**The Member-Secretary**

**Letter No. C3(S)/1374/2016****Dated : 27.03.2016**

**Sub:** CMDA – Area Plans Unit – MSB (South) Division - Planning Permission Application for the construction of Basement floor + Stilt floor + 11 Floors - Residential Multi-Storeyed Building with 22 dwelling units at Door No. 39, South Canal Bank Road, Raja Annamalaipuram, Mylapore, Chennai – 28, comprised in R.S.No. 4310/4, Block No. 96 and R.S.No.4569/16, Block No.100 of Mylapore village, Chennai – DC advice Sent – Reg.

PREMIUM FSI
அலுவலகப் பிடி

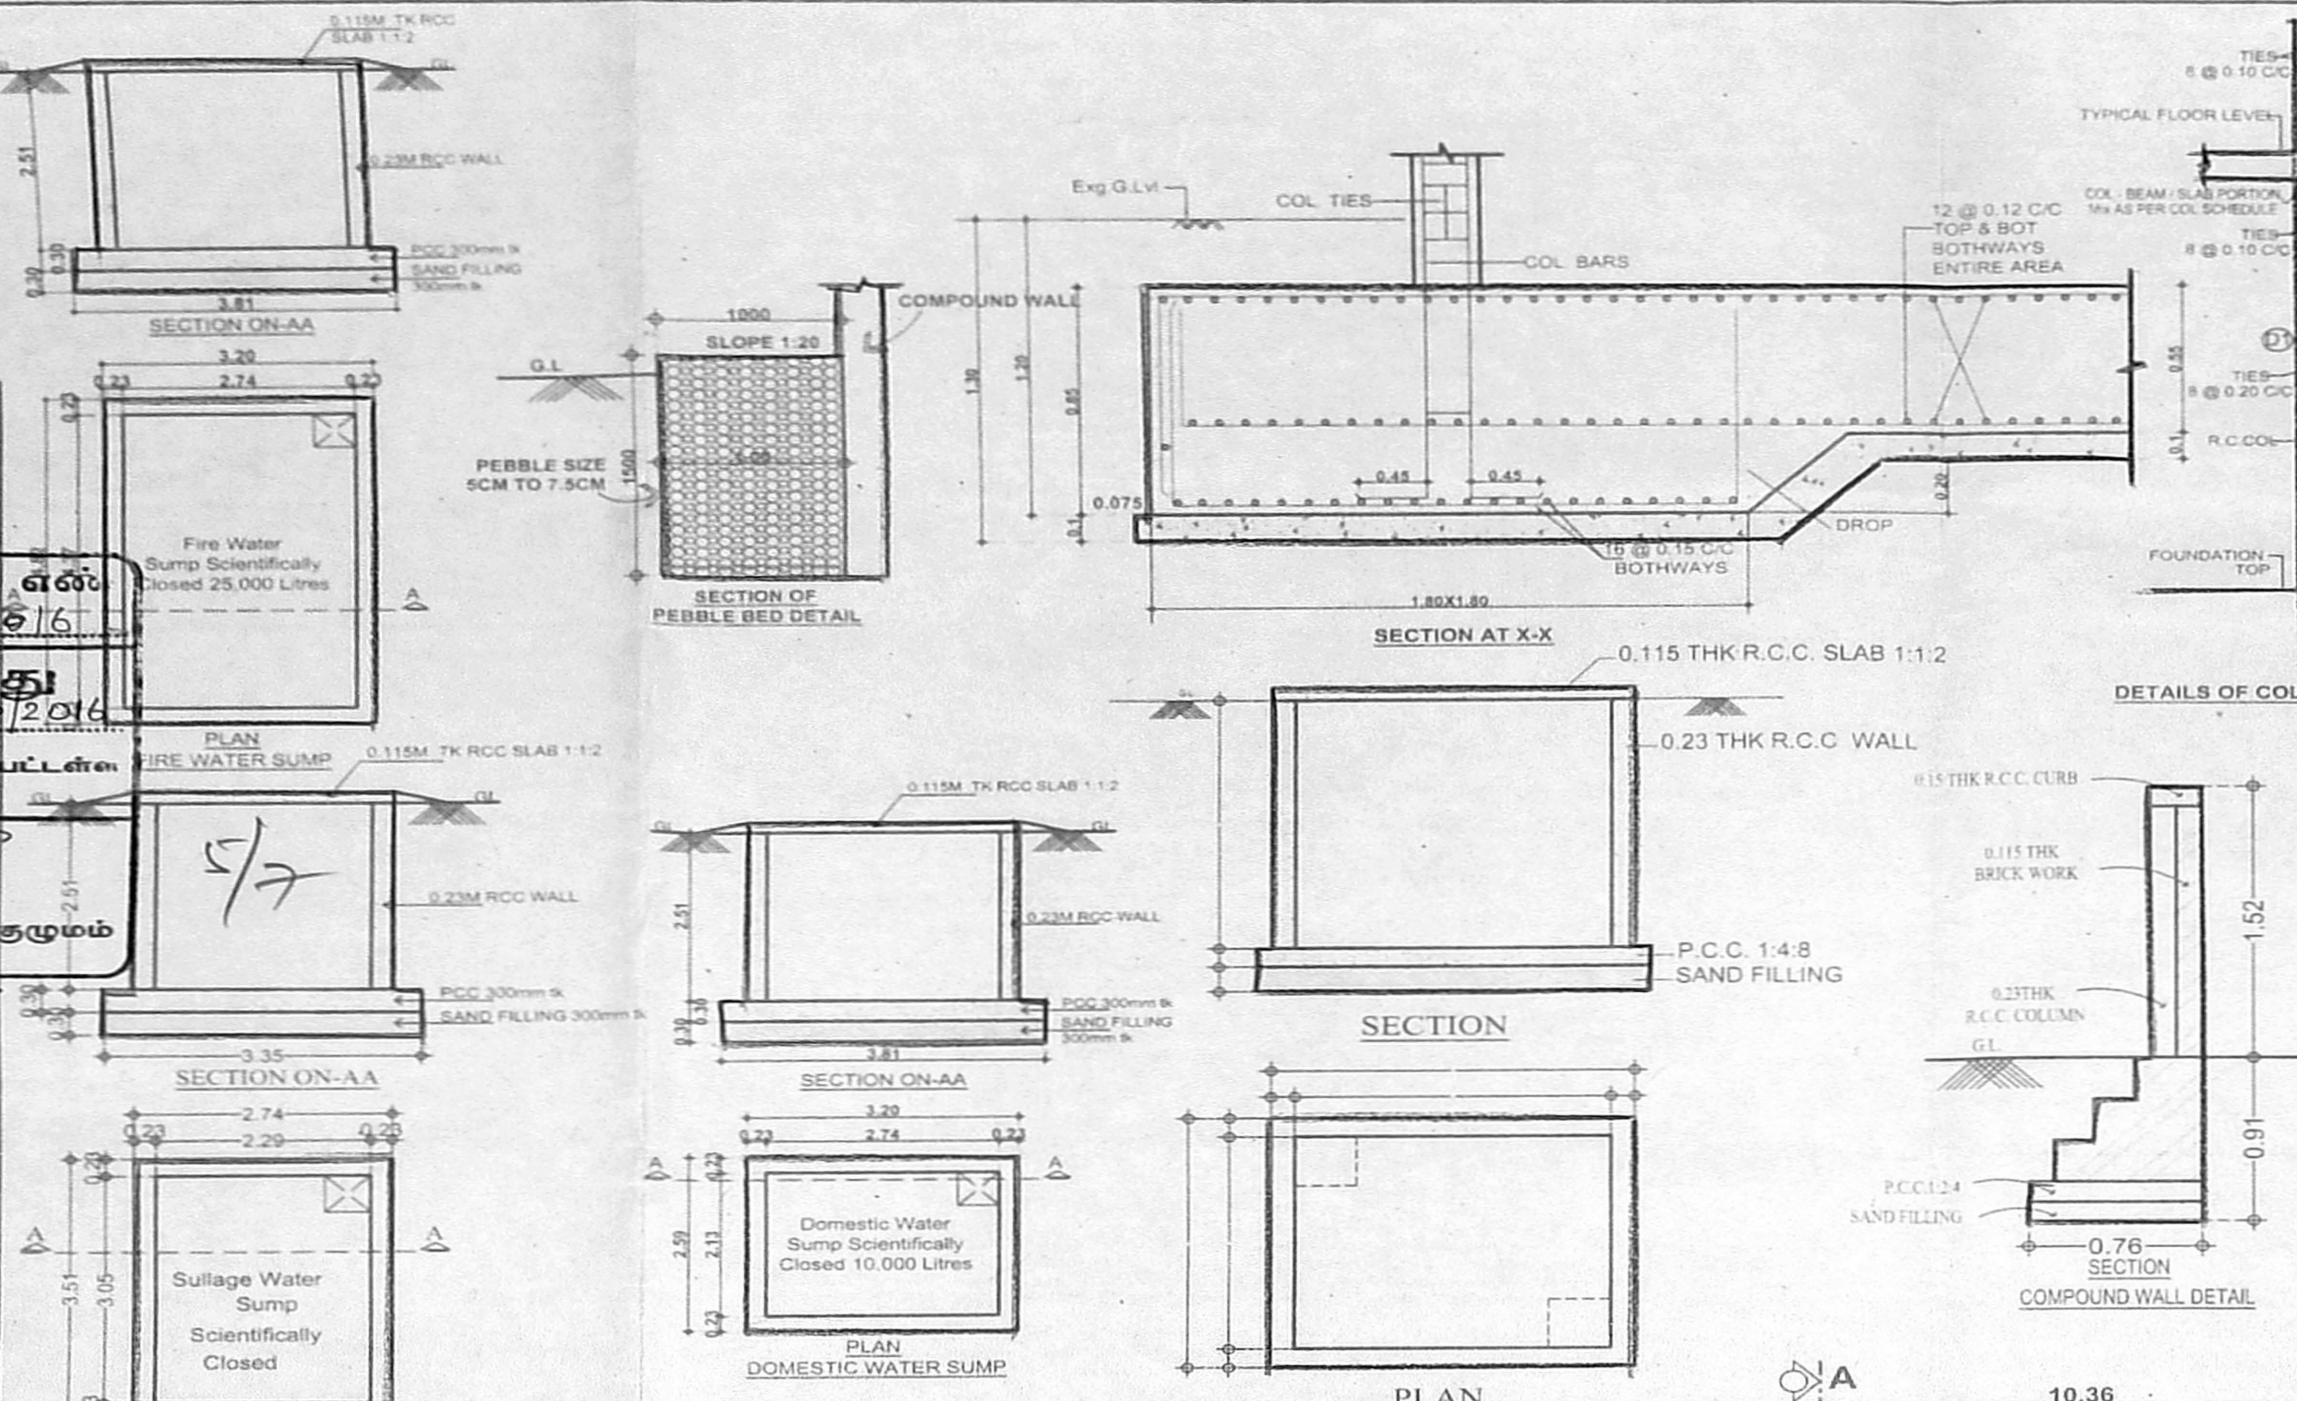
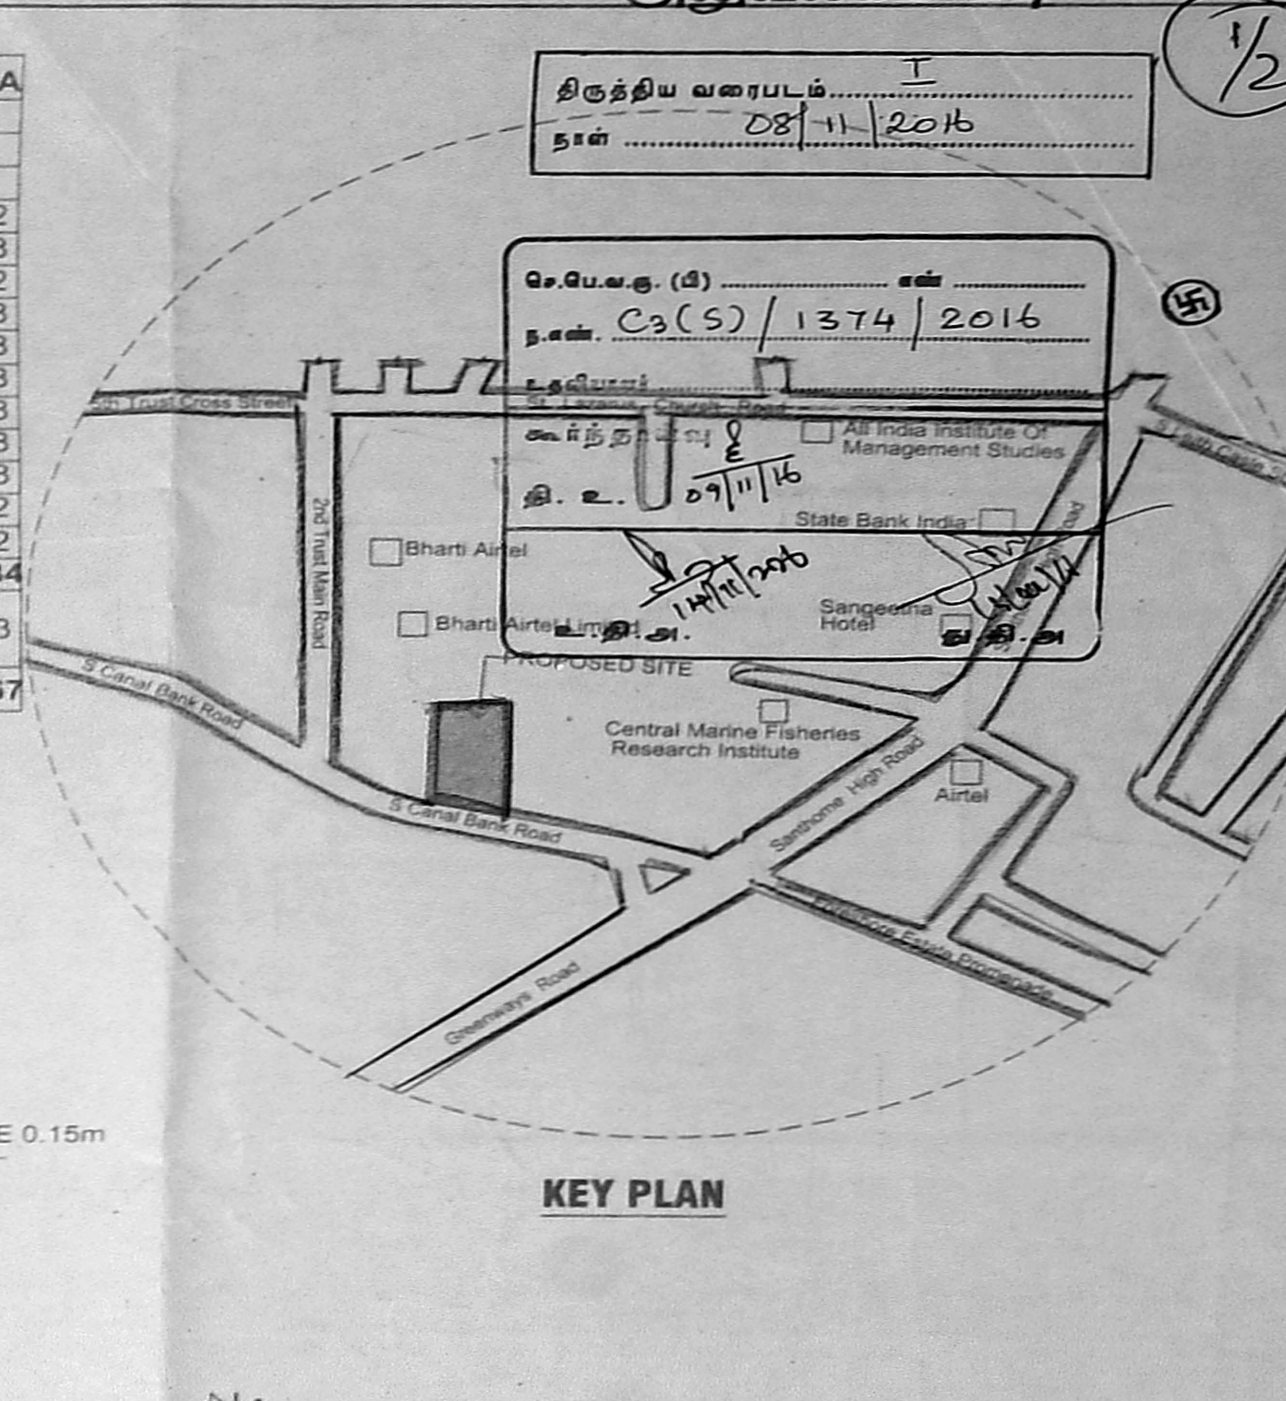
- (i) DG located at setback space is not permissible and hence the same is to be re-located either in Stilt floor or in Basement floor.
- (ii) All set in balconies and Utility are to be re-named as Service verandah provided with 1.0m height parapet wall/handrail and plumbing point.
- (iii) Electrical room is to be re-named as Electrical meter room.
- (iv) UG Sump for Rain water collection & Re-cycled Sullage water are to be provided.
- (v) The height of parapet is to be restricted to 1.0m at Terrace floor.
- (vi) Clear height of Basement floor and Stilt floor are to be mentioned in Cross section plan.
- (vii) As on site dimension and road width are to be shown tallying with inspection plan.
- (viii) Area statement to be corrected as per actual calculation.
- (ix) Sheet numbers are to shown as 1/3, 2/3 and 3/3.

(x) Transformer yard & security cabin are to be located after leaving min. required setback of 7.20m

(xi) Gym intended for human habitation proposed in Basement floor without ventilation is not permissible.
